From: Simon Davis
Sent: 13 October 2020 11:37
To: Maddi Simpson [REDACTED]
Subject: RE: 020.5360 Land West of Fontwell Avenue ref BN/50/20/PL

Tree Constraints Plan

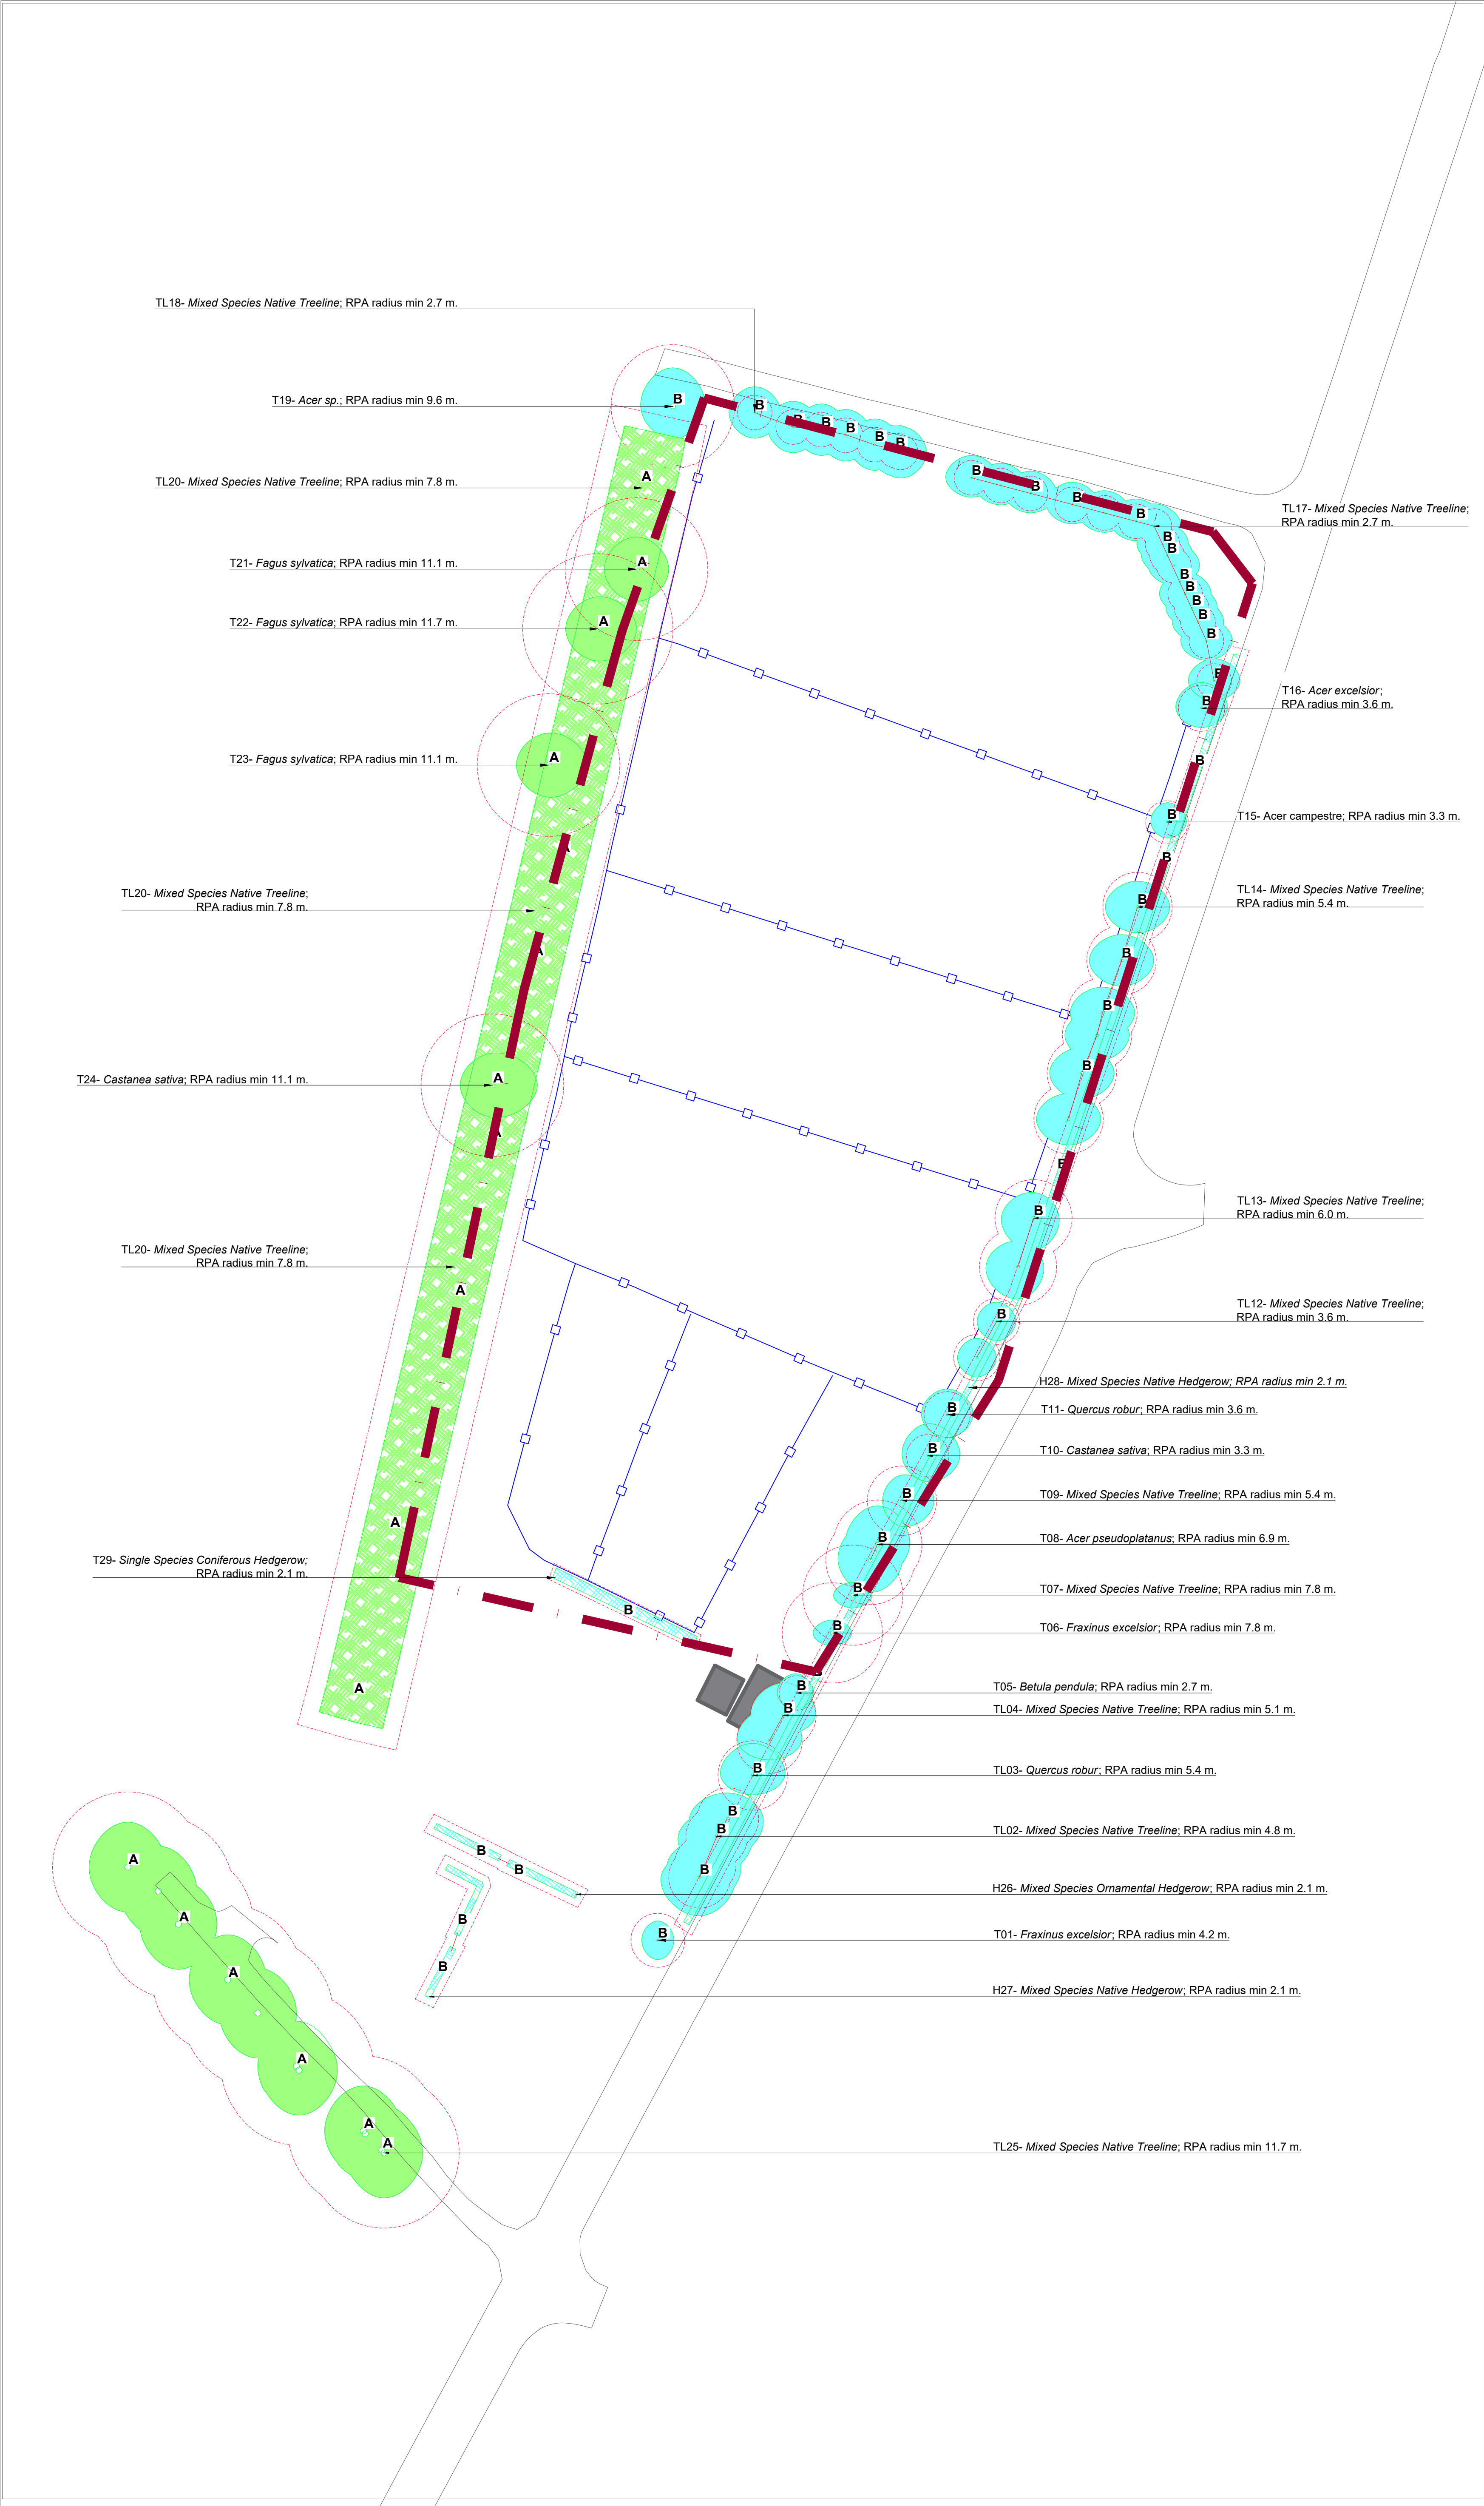
Although the report has been agreed, it has been pointed out to me that the loss of the 13 category B trees along the site frontage has an impact on biodiversity and impacts upon the net gain that the enhancements demonstrate.

I note that our ecologist asked that any trees lost are replanted on a 2 for 1 basis, also that our Tree Officer asks that any planting scheme is dominated by native tree species of potential stature (min. 10-15m ht.).

We already have a landscape scheme in the recommendation but I am thinking to amend this to specifically request 26 new native trees to include those that will have potential stature. However, there is no point doing this if you don't have room on the site. Therefore, can you advise if it would be possible to provide 26 new native trees across the layout and if so, whether it would be appropriate for any to grow to 10m+ high.
